Preliminary & Final Drainage Report
for
Rex Road
through
Falcon Regional Park

MERIDIAN RANCH
A GOLF & RECREATIONAL COMMUNITY

EL PASO COUNTY, COLORADO

February 2023

REX ROAD - PDR/FDR

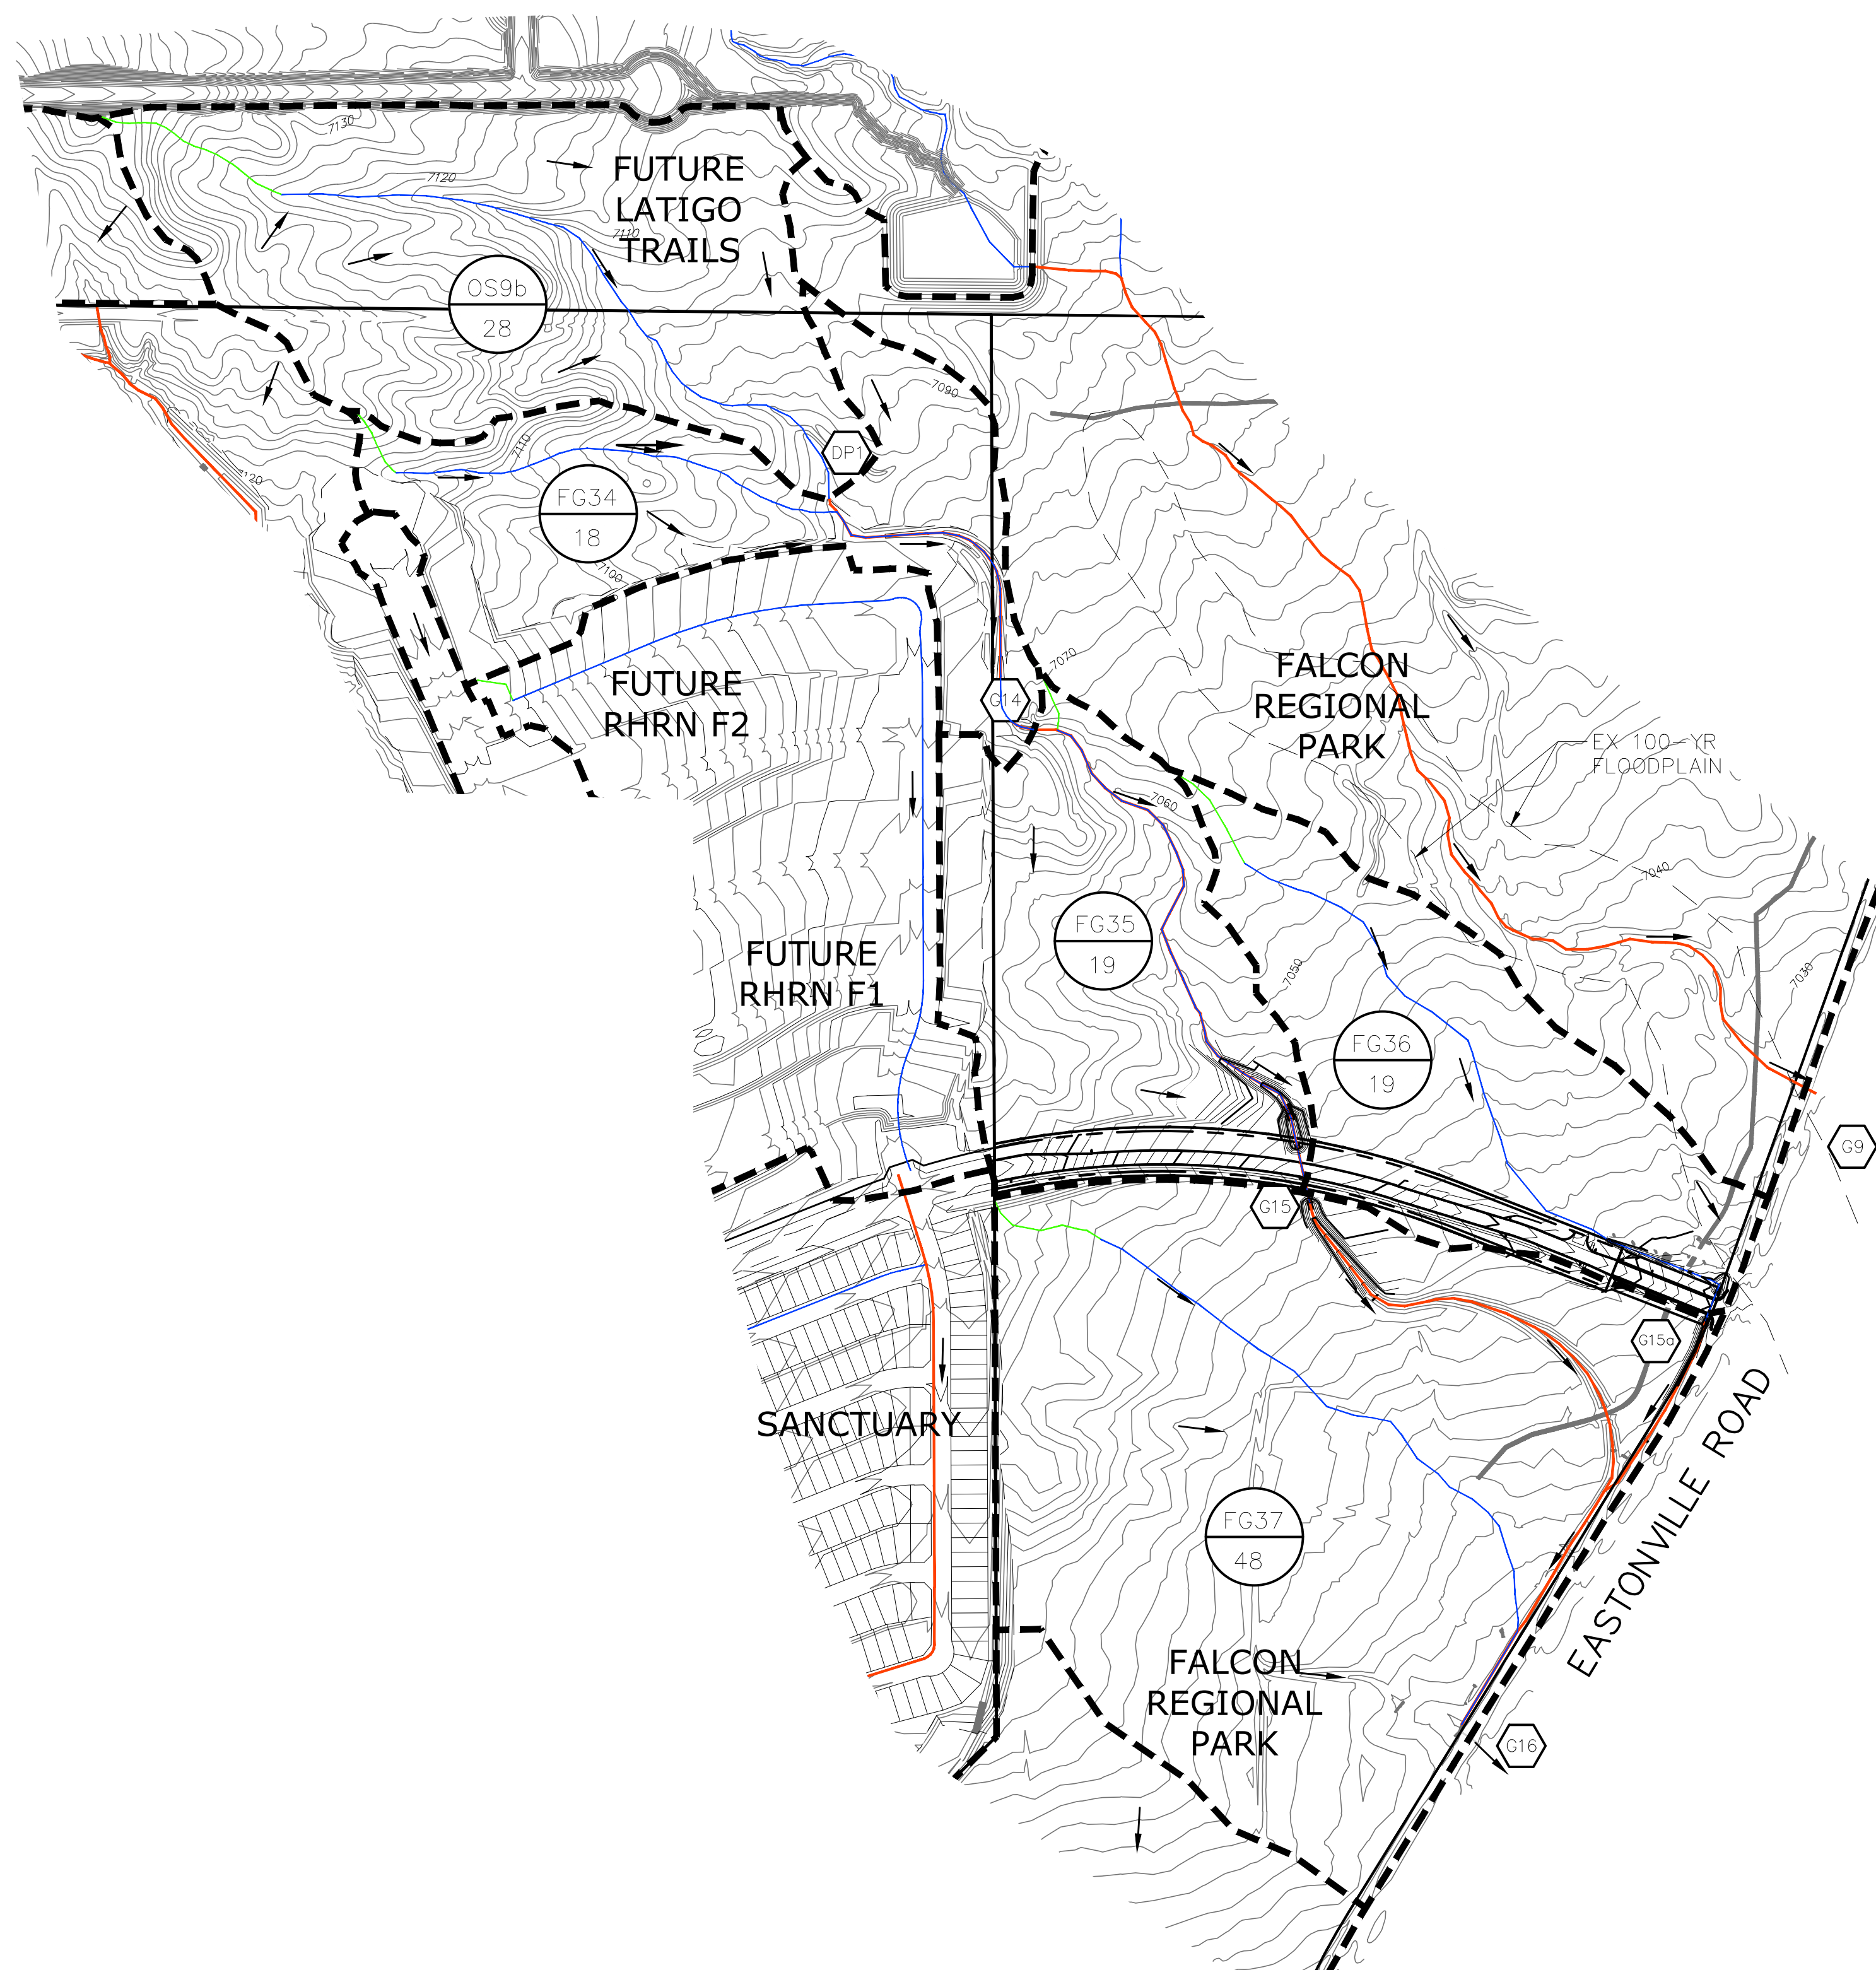
discuss historic conditions in text.

The drainage area for G14 and G16 are less than the existing condition. If the existing drainage patterns are not being altered in the proposed condition, these would be the same areas. Discuss changes to drainage patterns that results in this reduction in area and analyze if that is acceptable or update areas.

REX ROAD - PDR/FDR RATIONAL MAP

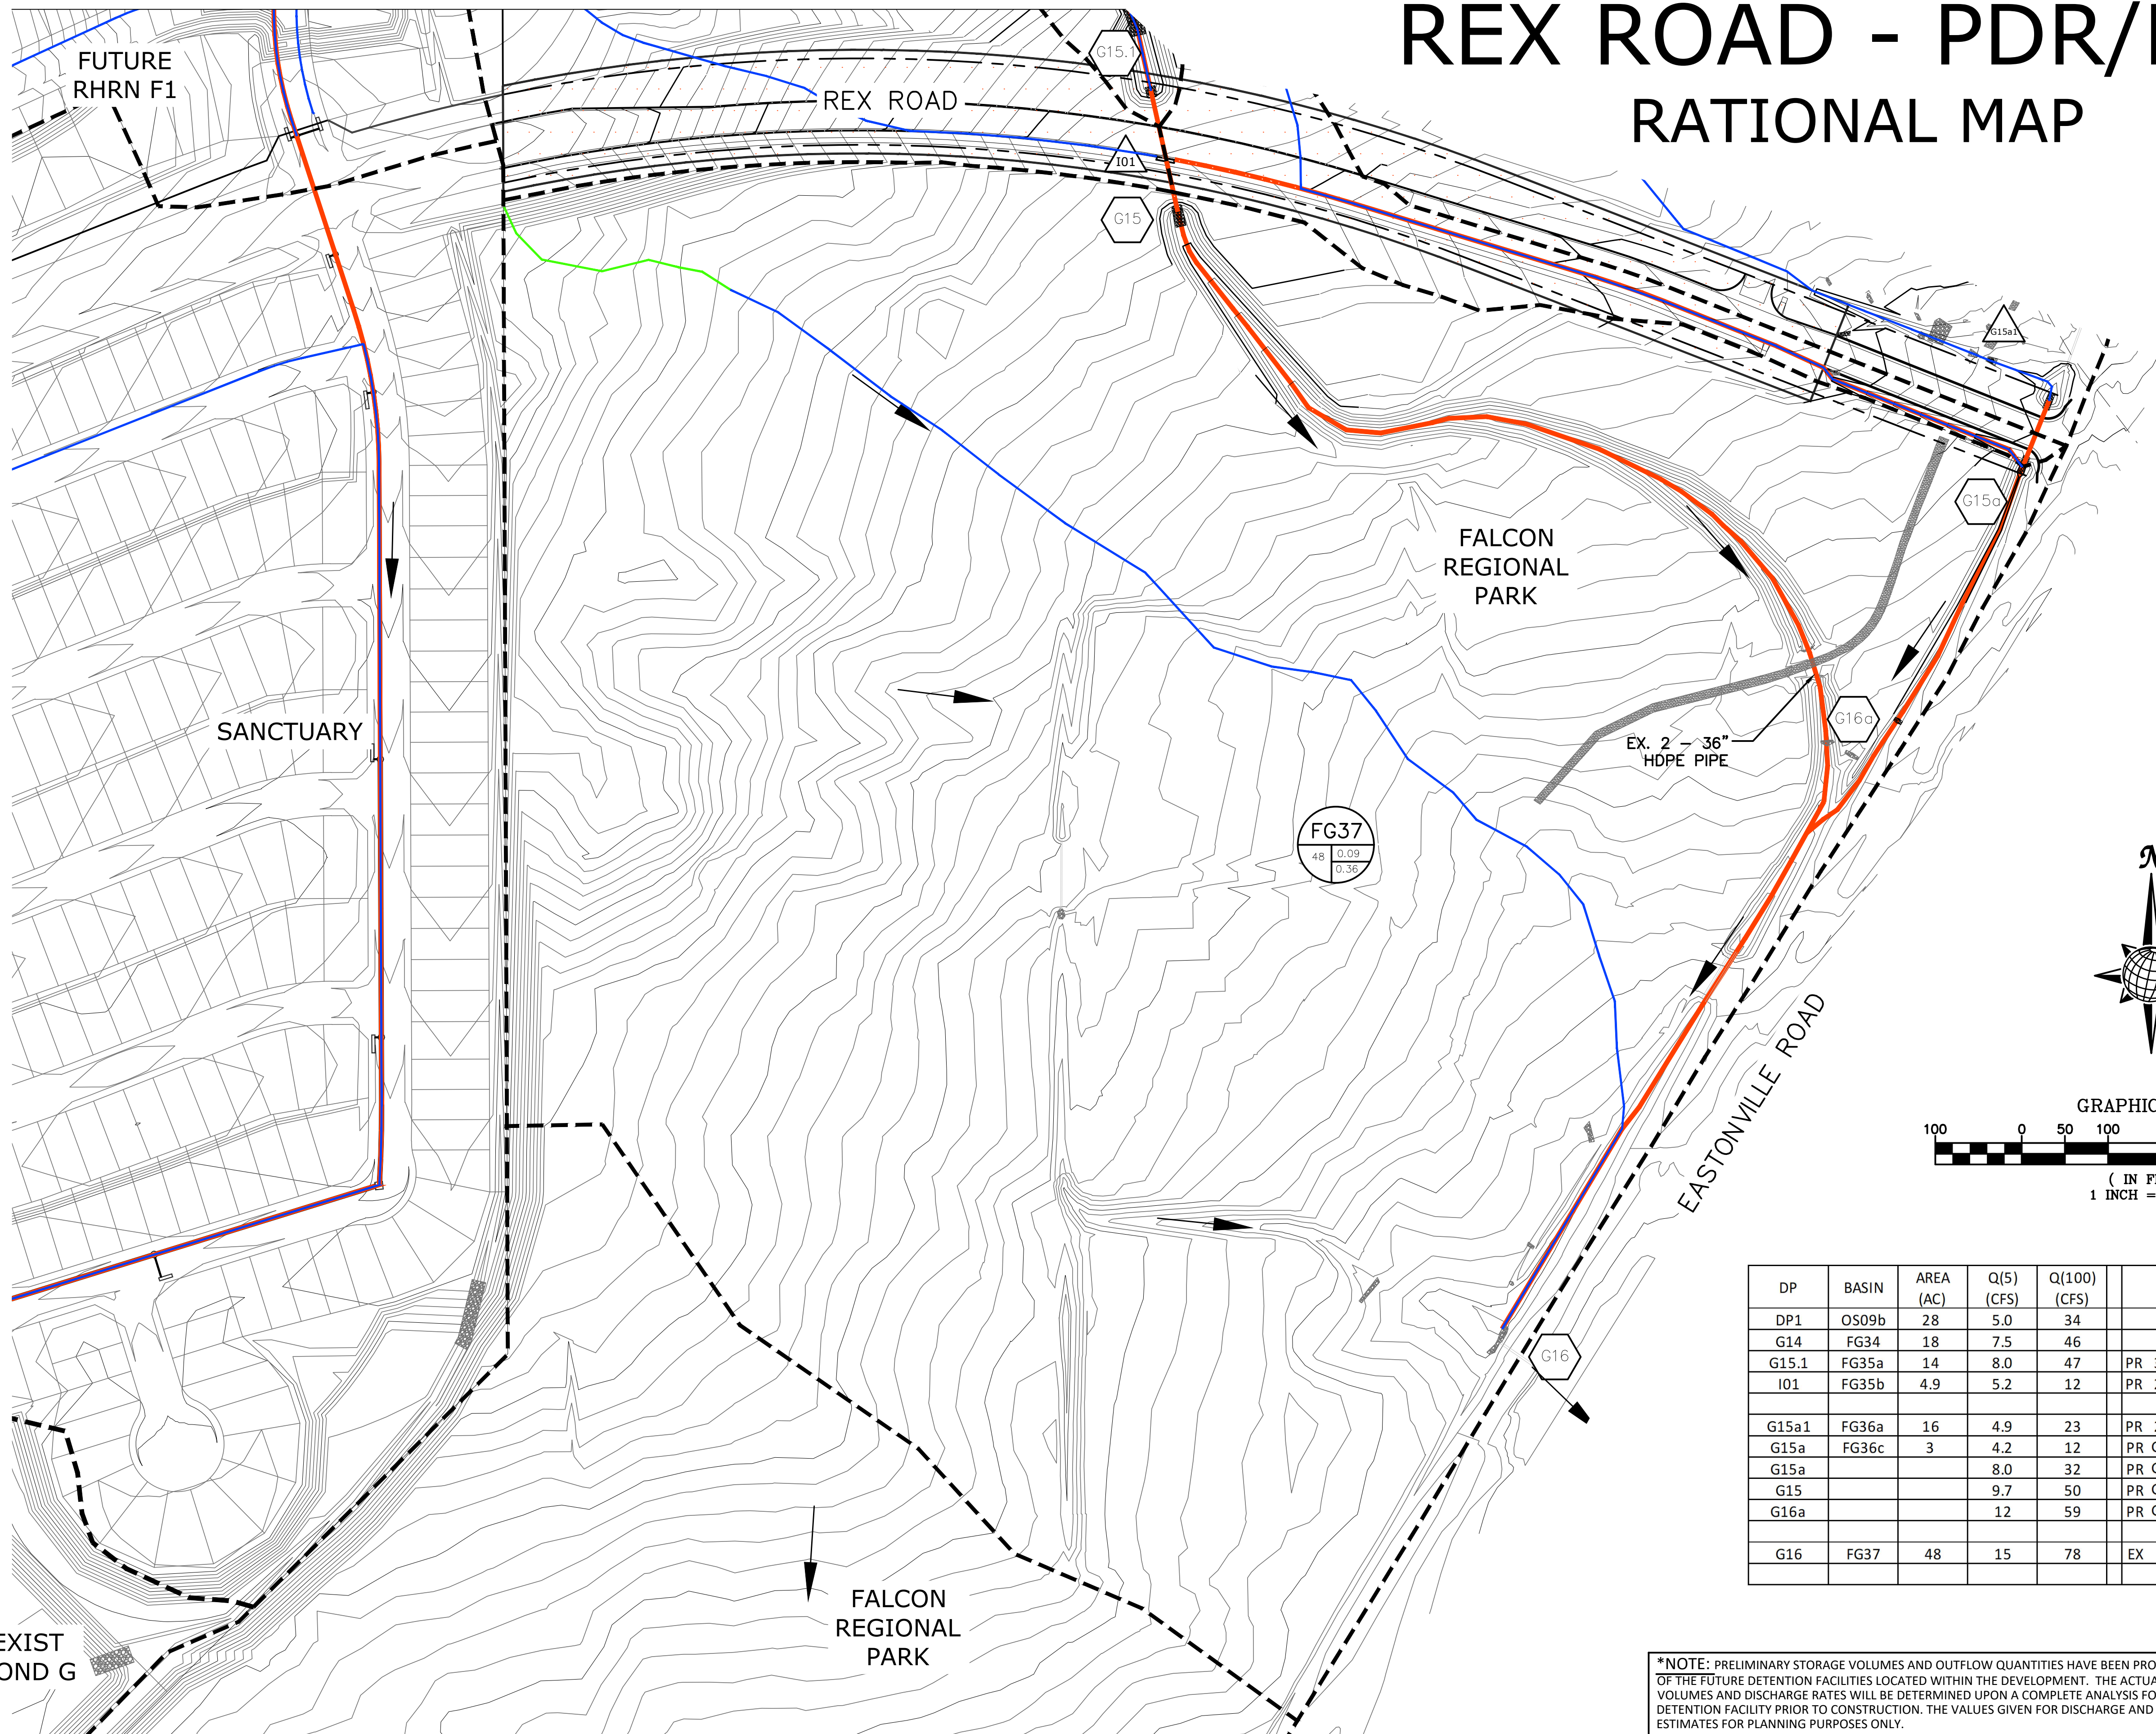
Rational Narrative flows in this section do not match Figure 5
